# CITY OF ALBUQUERQUE

June 10, 2019

**RE: 8500 Glendale Ave. NE**  
**Grading and Drainage Plan**  
**Engineer's Stamp Date: 05/28/19**  
**Hydrology File: B20D067**

TITLE: **8500 Glendale Grading & Drainage Plan**

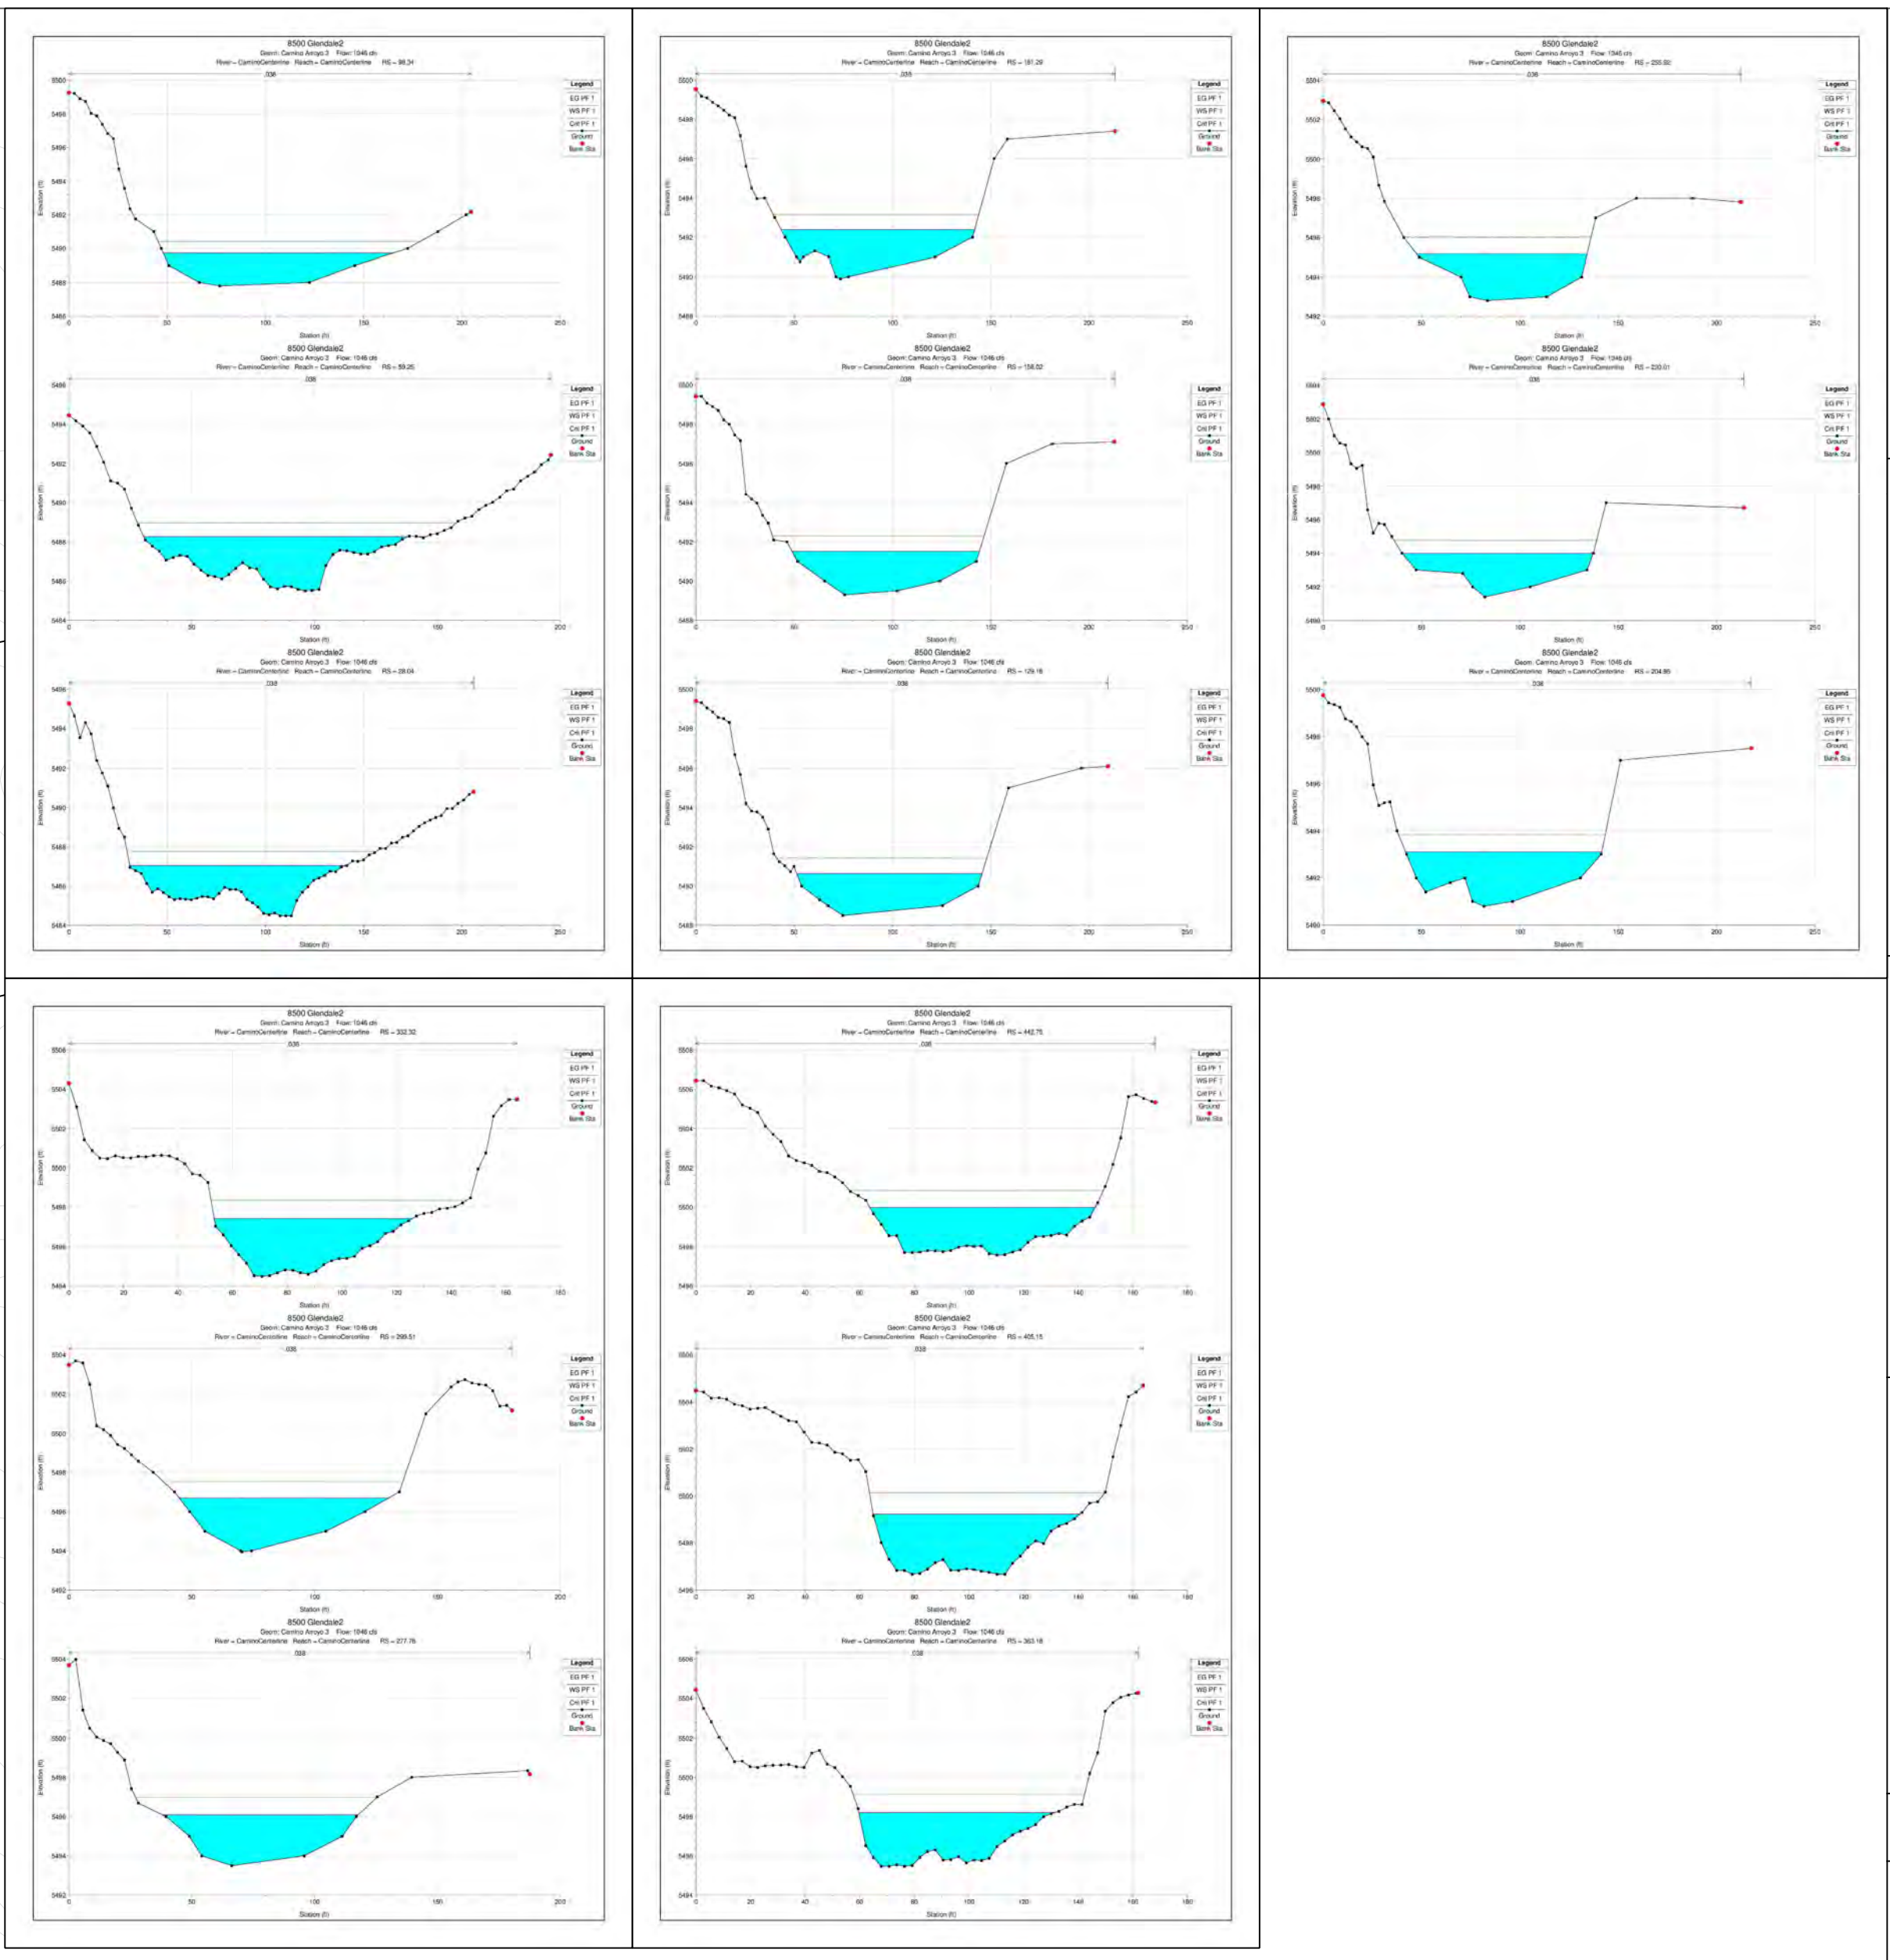
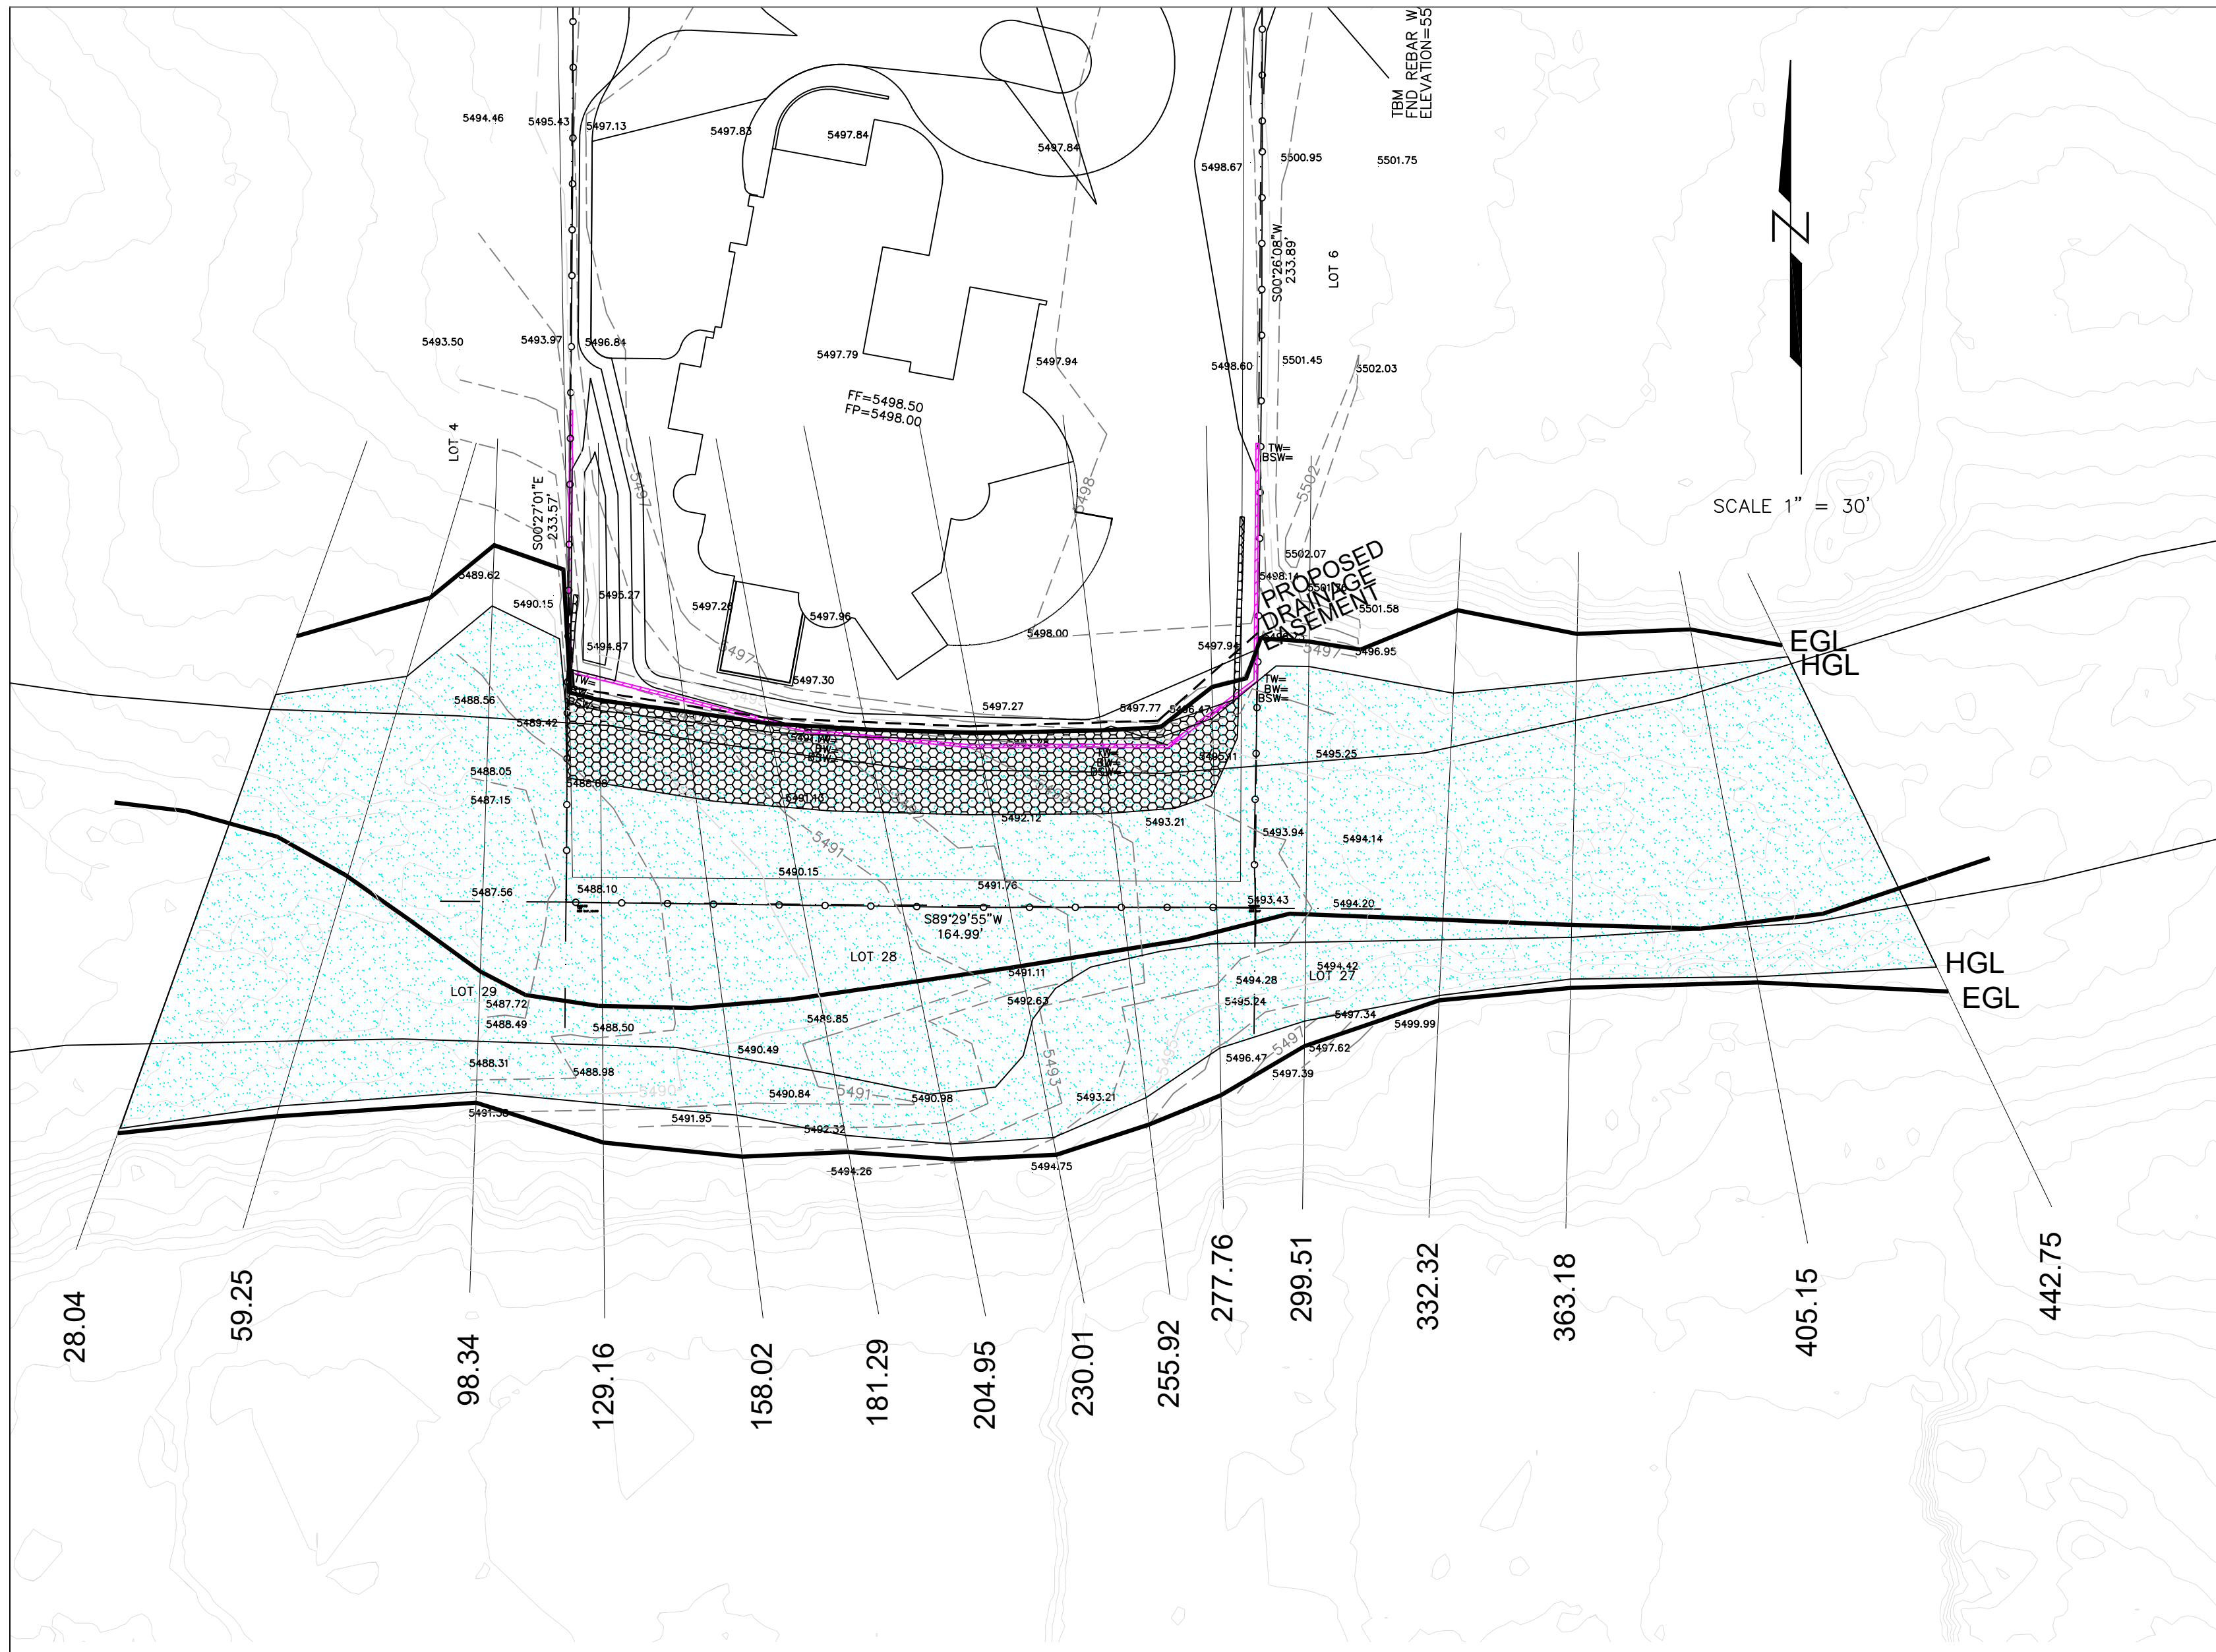
2. At the northwest and northeast corners of the property, there are proposed grading on the adjacent properties. Written approvals from both of the adjacent property owners are required prior to Building Permit approval.
